Location: Land off Back Lane Chipping PR3 2QA
Proposal: Proposed change of use of land to tourism and erection of five camping pods.
Grid Ref: 361993 441328

Lancashire County Council acting as the Local Highway Authority (LHA) does not consider that the application as submitted fully assesses the highway impact of the proposed development and further information is required as set out in this response.

The Local Highway Authority (LHA) are in receipt of an application for the proposed change of use of land to tourism and the erection of five camping pods at Land off Back Lane Chipping PR3 2QA.

Job No: 251001	Drawn By: J.L.
Date: Dec 2025	Checked By: J.L.
Scale: 1 / 500 @ A1	Drawing No: 251001 / 01

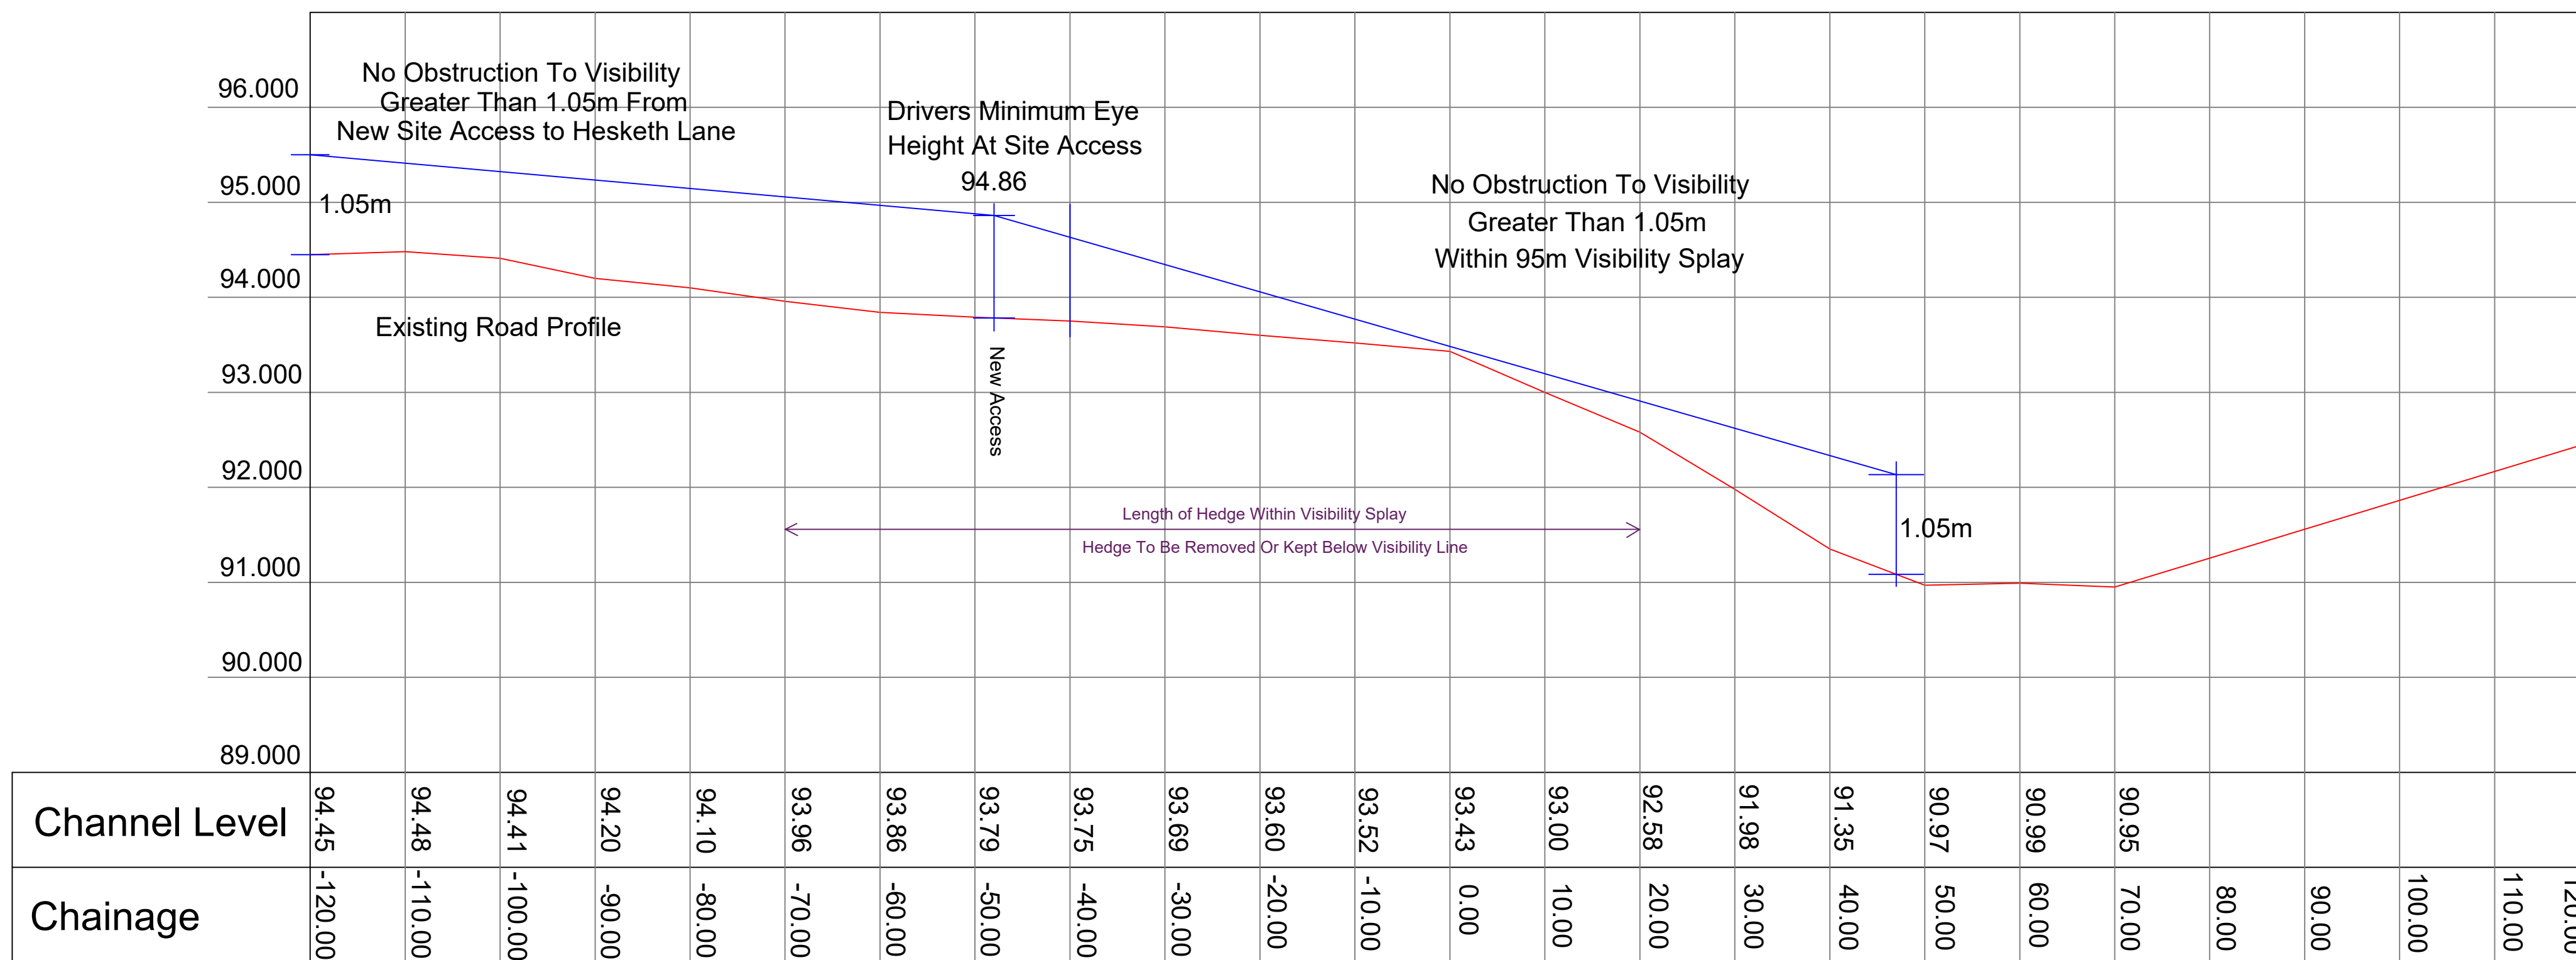
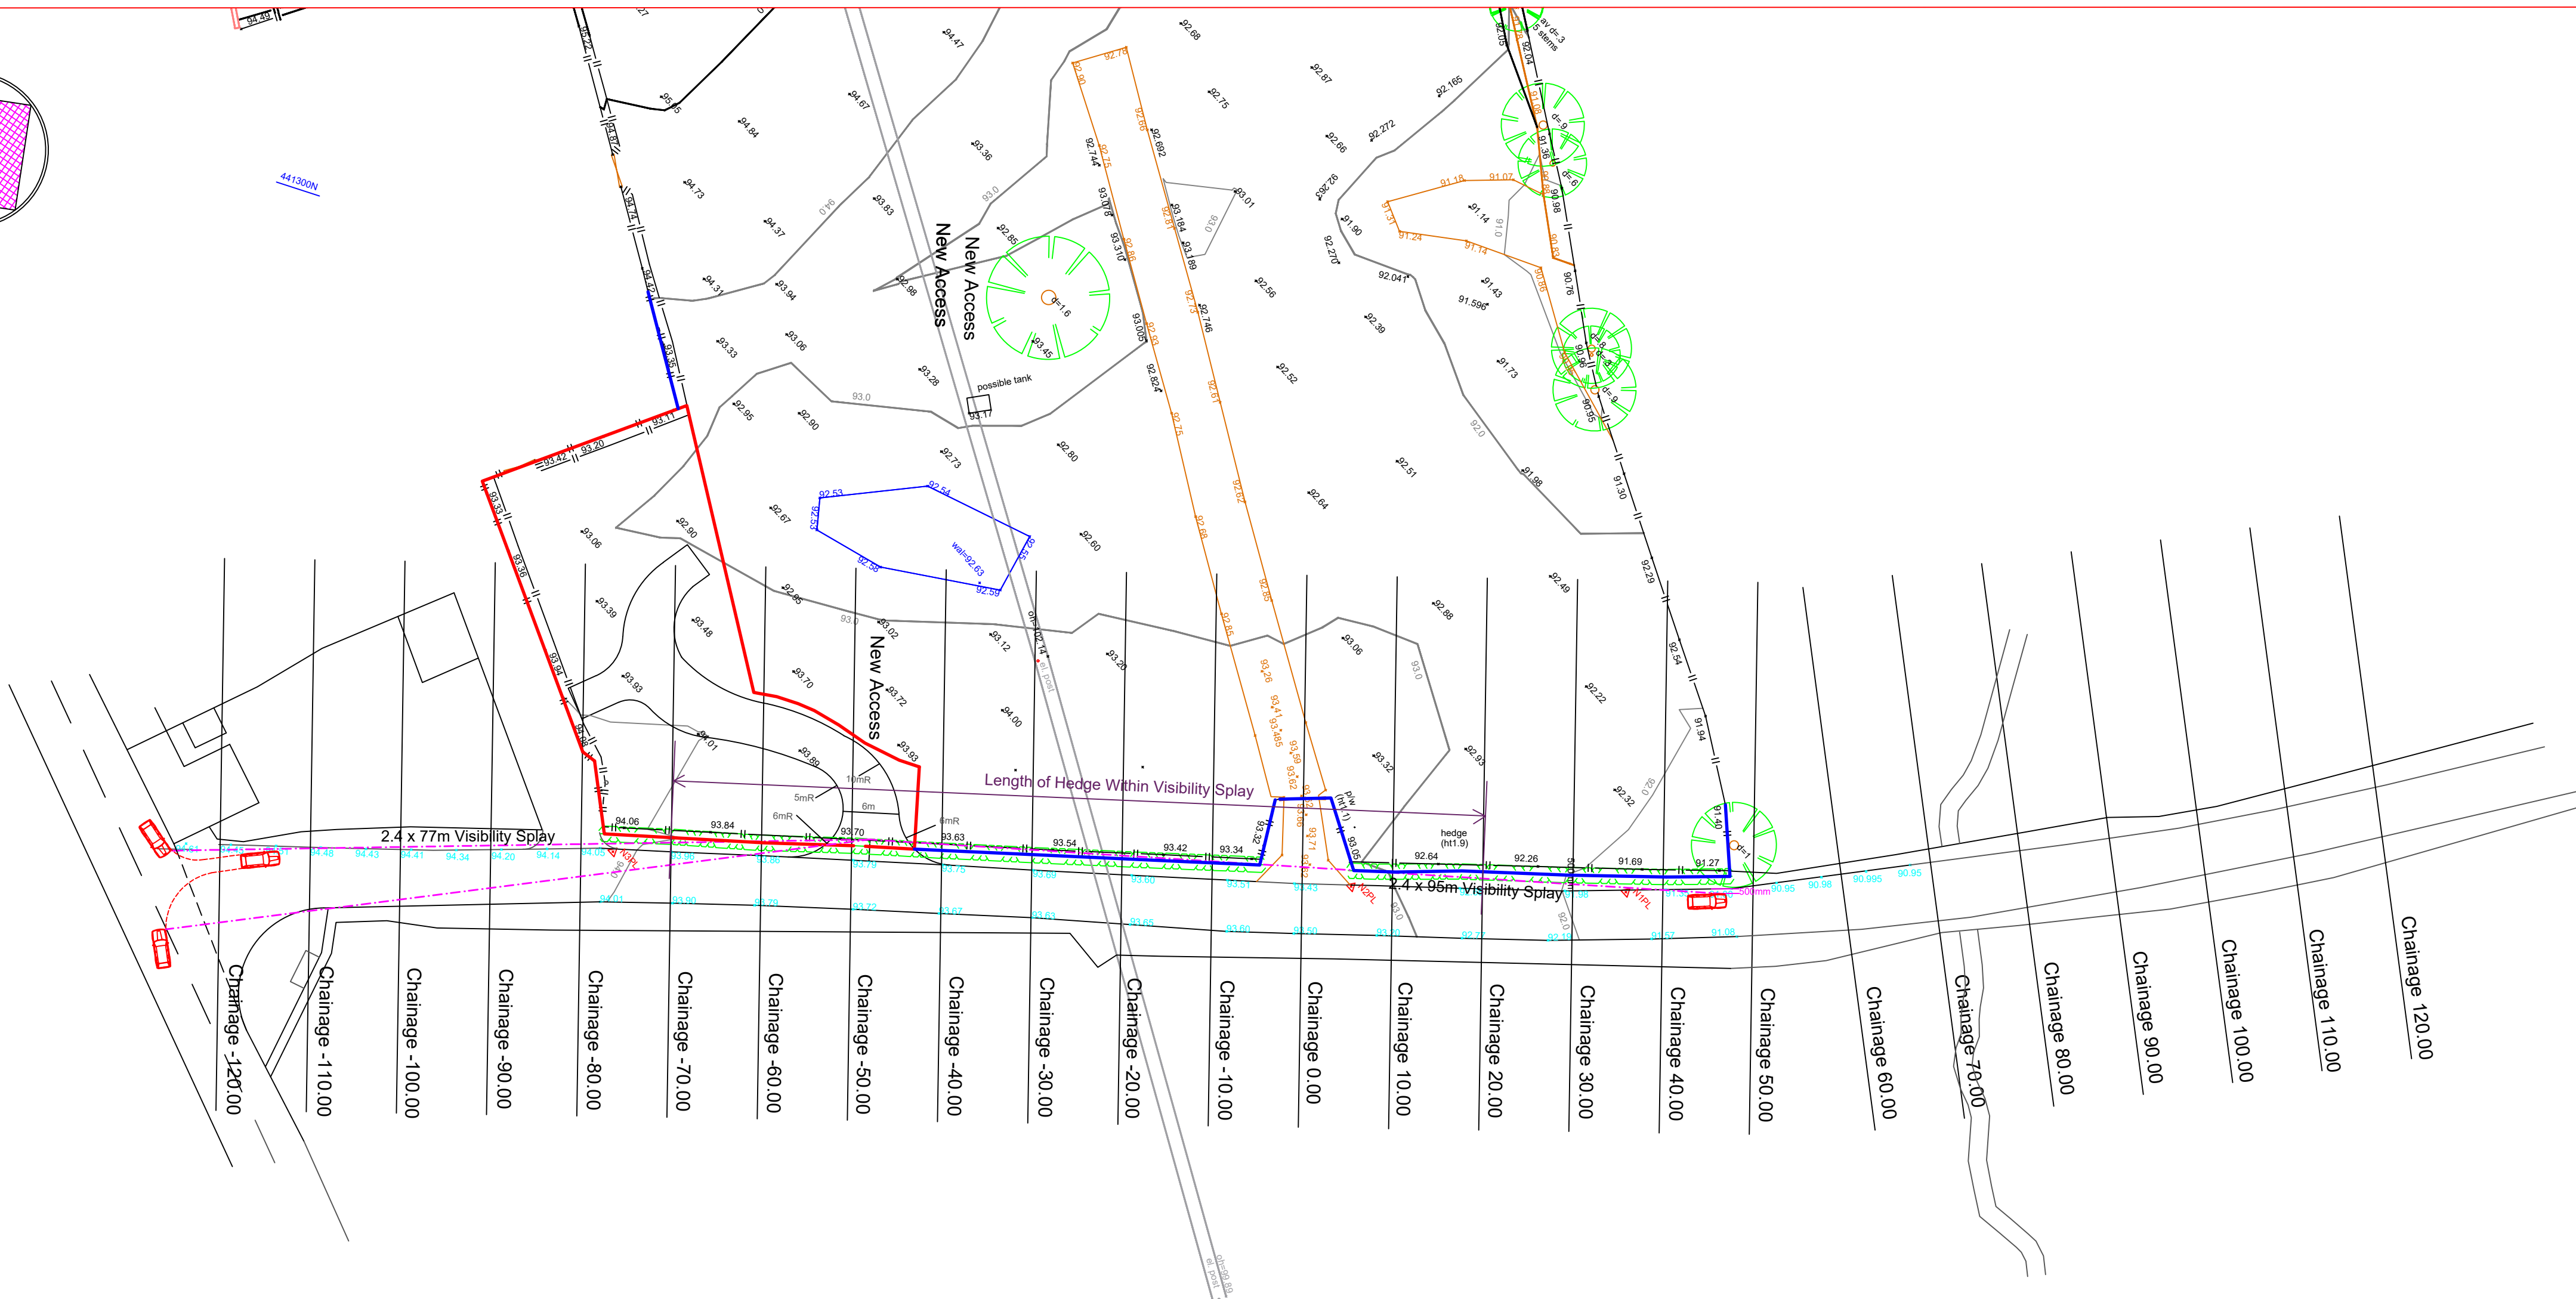
The preferred calculated visibility distances using DMRB are 102 m to the south and 95 m to the north. The applicant has provided a visibility splay within drawing number 251001/01. The drawing shows that the visibility to the north can be achieved and that the splay to the south provides clear visibility up to the junction with Hesketh Lane which is acceptable.
